Application No: CM/38/21/PL
Site Address: The Arundel Gardener and Maidenhead Aquatics Crookthorn Lane Climping BN17 5SN
Description of works: Retention of timber cladding to side (west) & rear (south) of main building, Laying new shingle to existing made ground, lychgate to west of main building, timber cladding to generator housing & laying block paving and concrete slabs/replacement concrete slabs. This site may affect a listed building & is in CIL Zone 5 (Zero Rated) as other development.

Thank you for your internet representation made on 17th August 2021 which has been recorded as an objection with the comments as follows:

*As-Existing Site Plan
with Proposals*

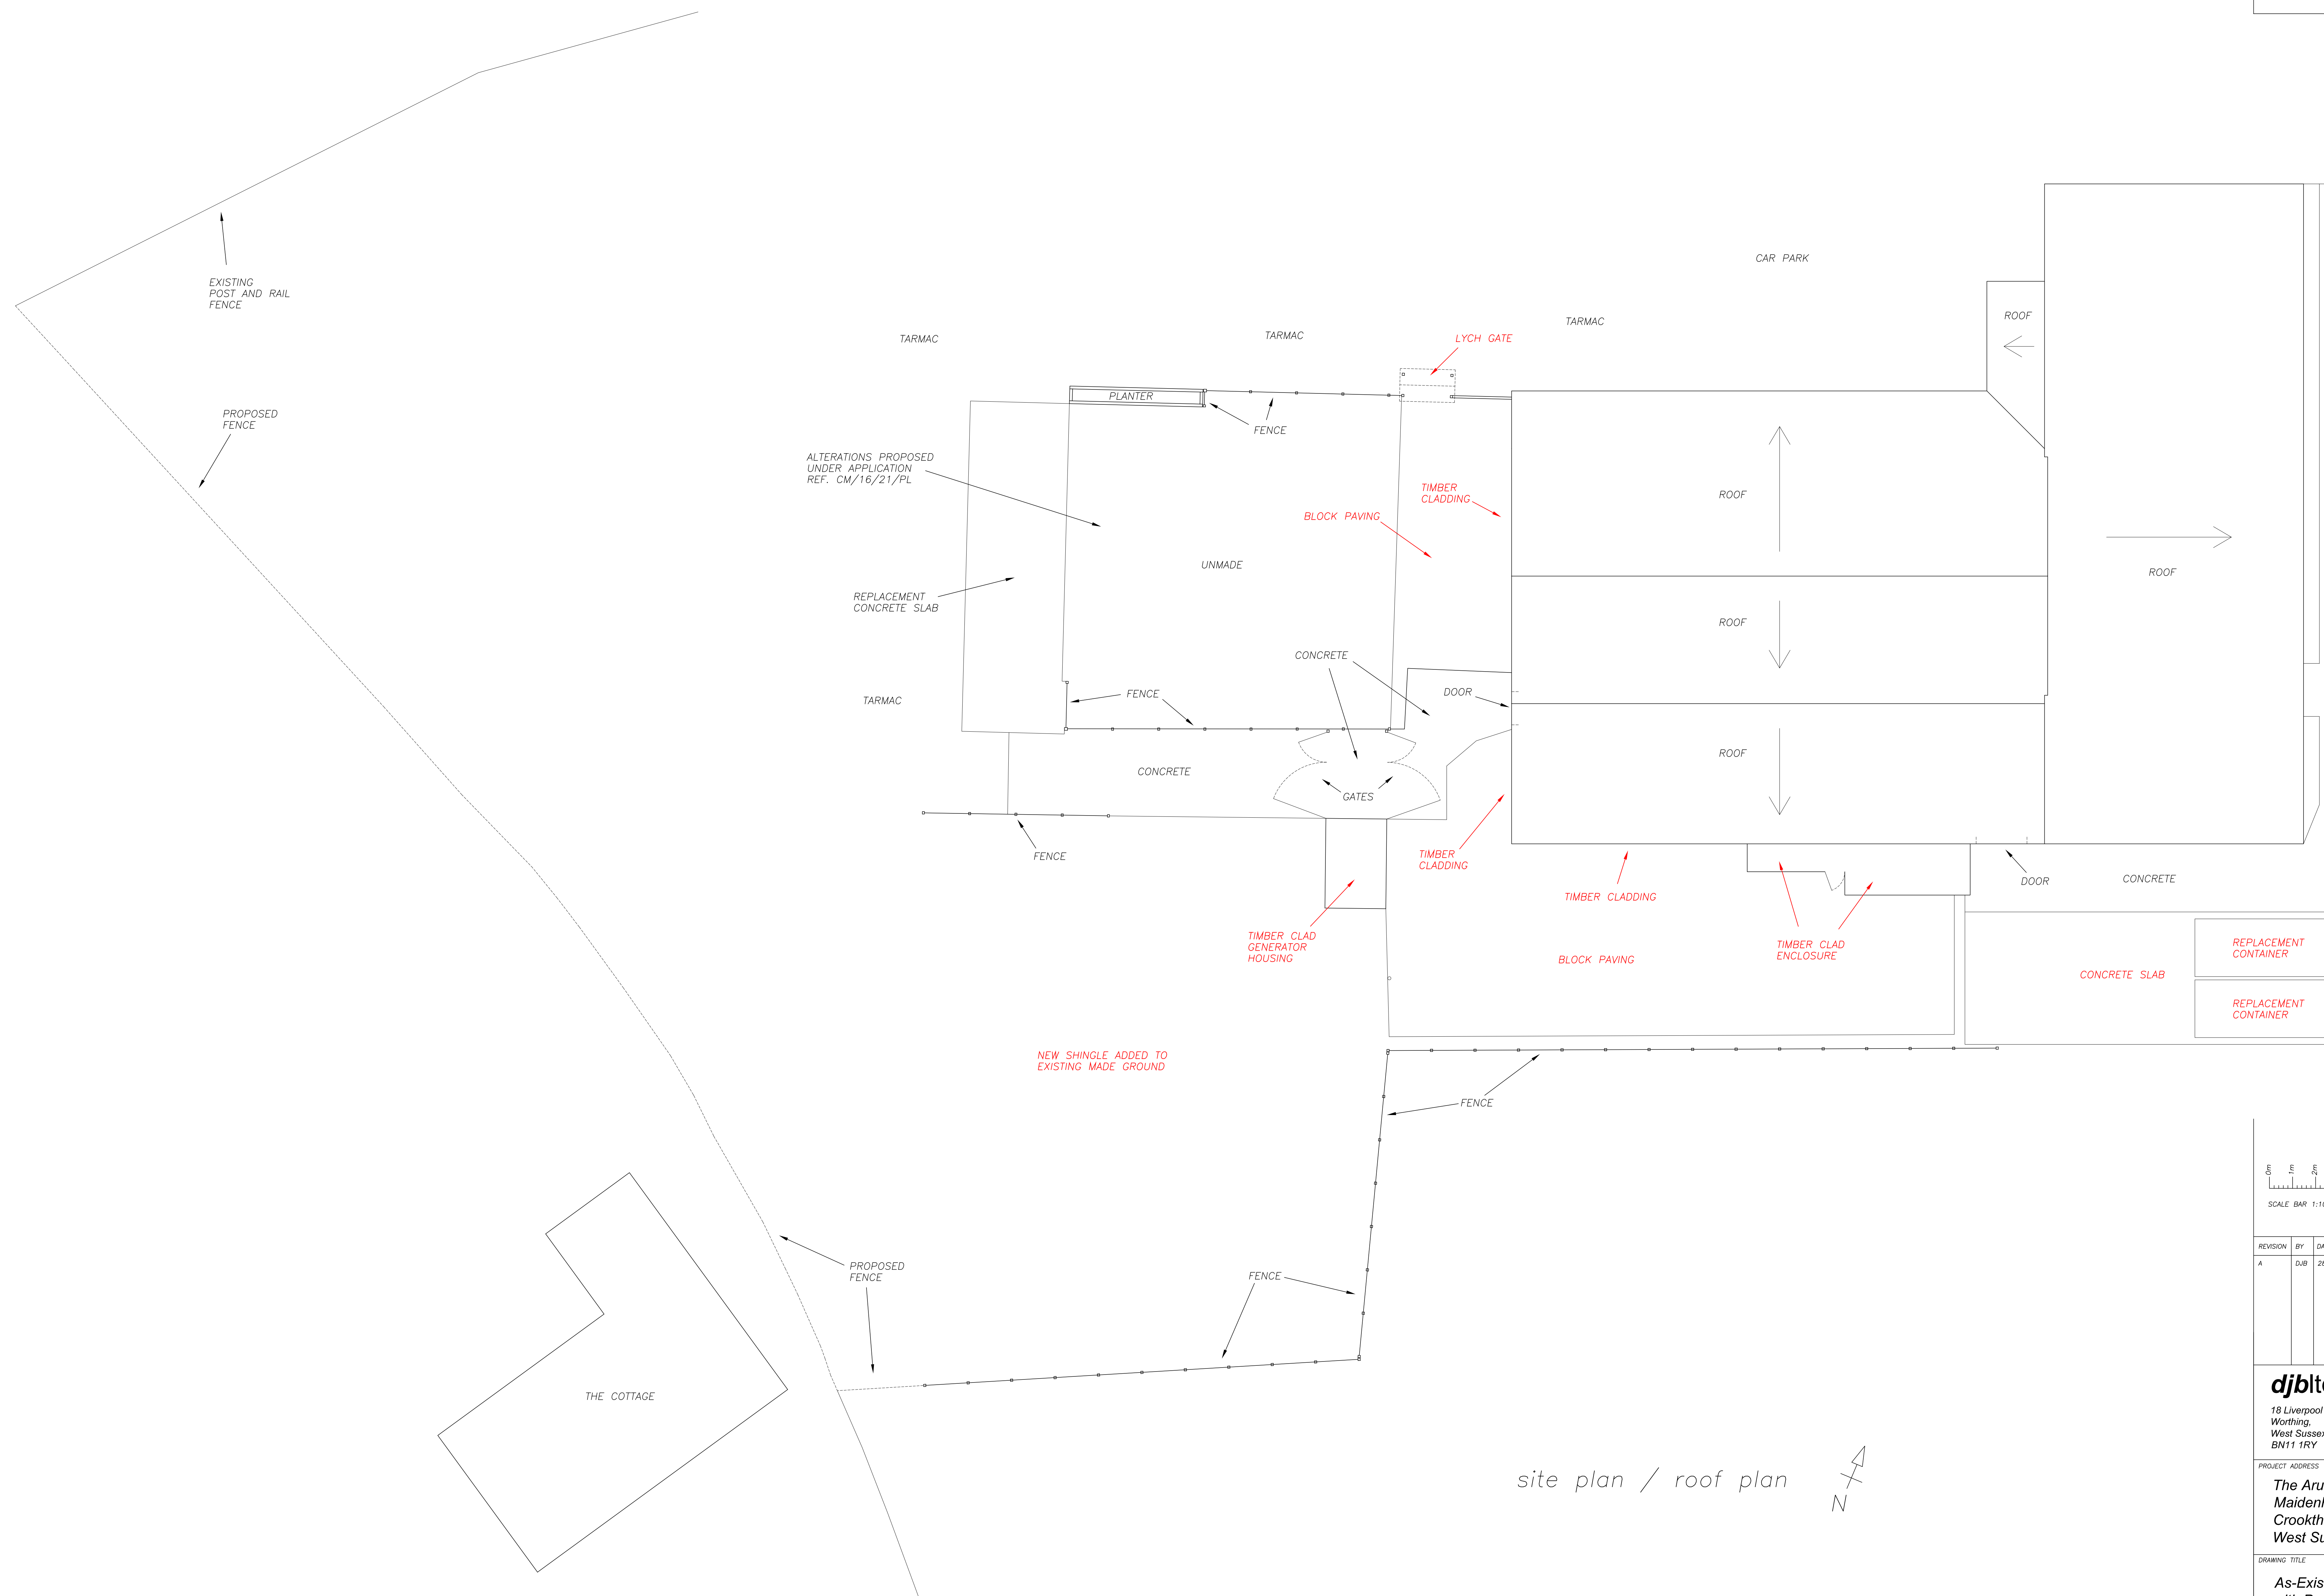
The claim that shingle has been added to existing made ground is false. This area was part of a grass field, complete with polytunnel which was removed when groundworks commenced. Shingle was laid on top of a layer of hardcore, brought in by commercial vehicle by the contractor carrying out the landscaping works on the site. This area of shingle covered hardcore has been extended close to the boundary with the garden of the Grade II Listed cottage adjacent to the site. Customers using the fast-food cafe outside seating area will be clearly visible and audible from inside the kitchen and lounge of the property, and especially from the garden.

**As-Existing Elevations
with Proposals**

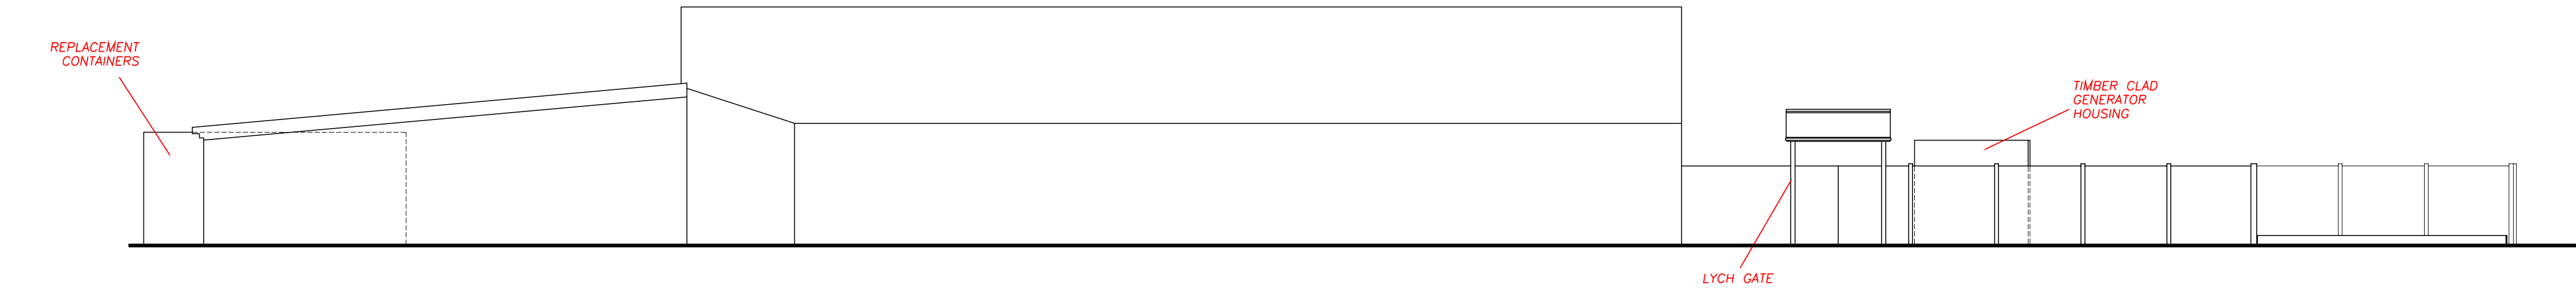
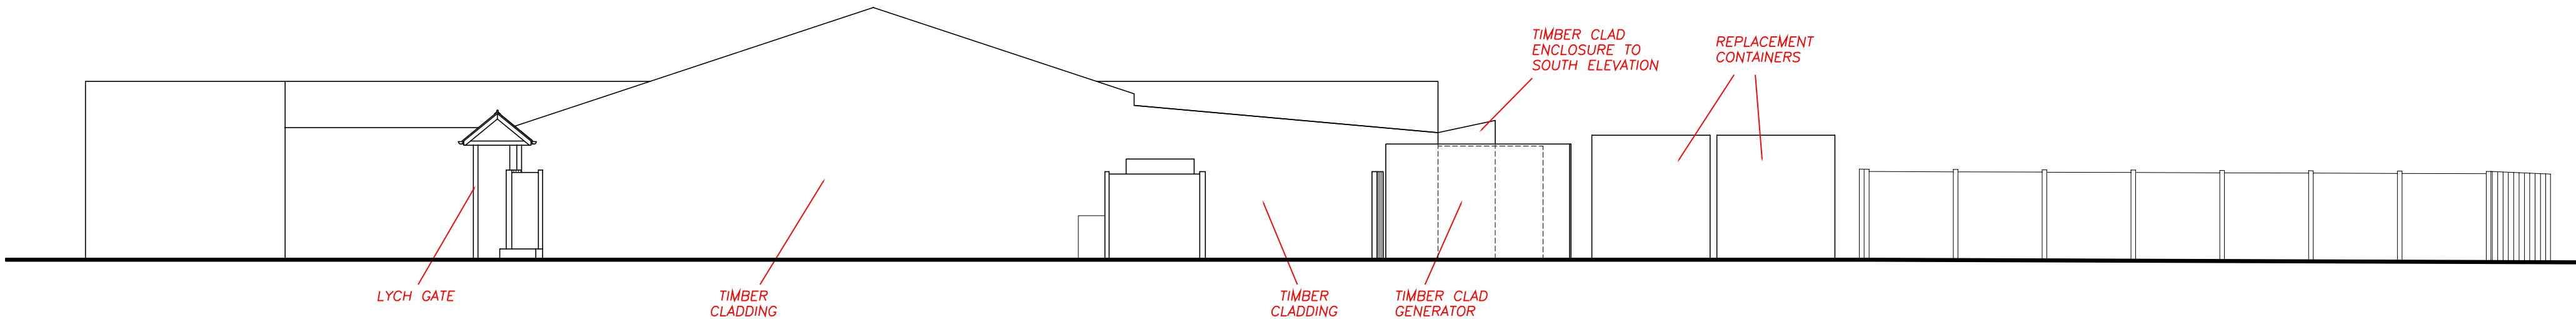
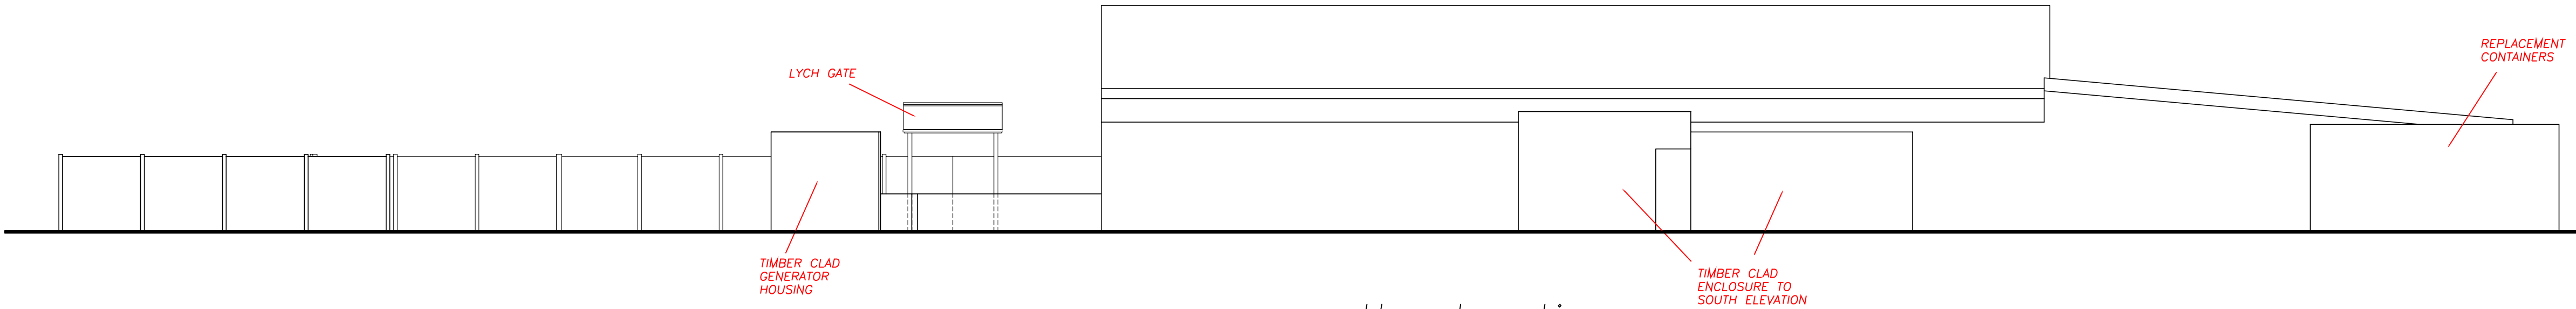
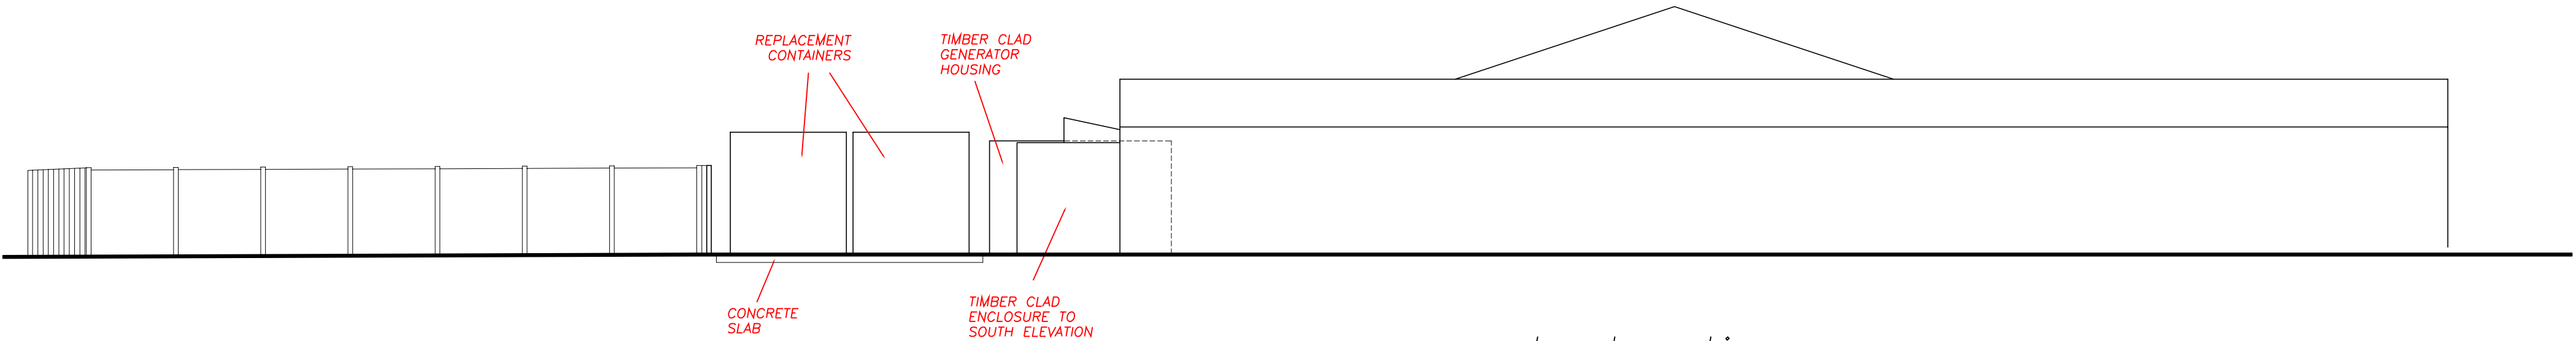
The original green agricultural-style building was in keeping with the site's former use as a farm shop and blended into its rural surroundings. The new timber cladding has the opposite effect of making the building stand out from its rural setting, and of increasing its visibility as a commercial business to drivers on the A259,
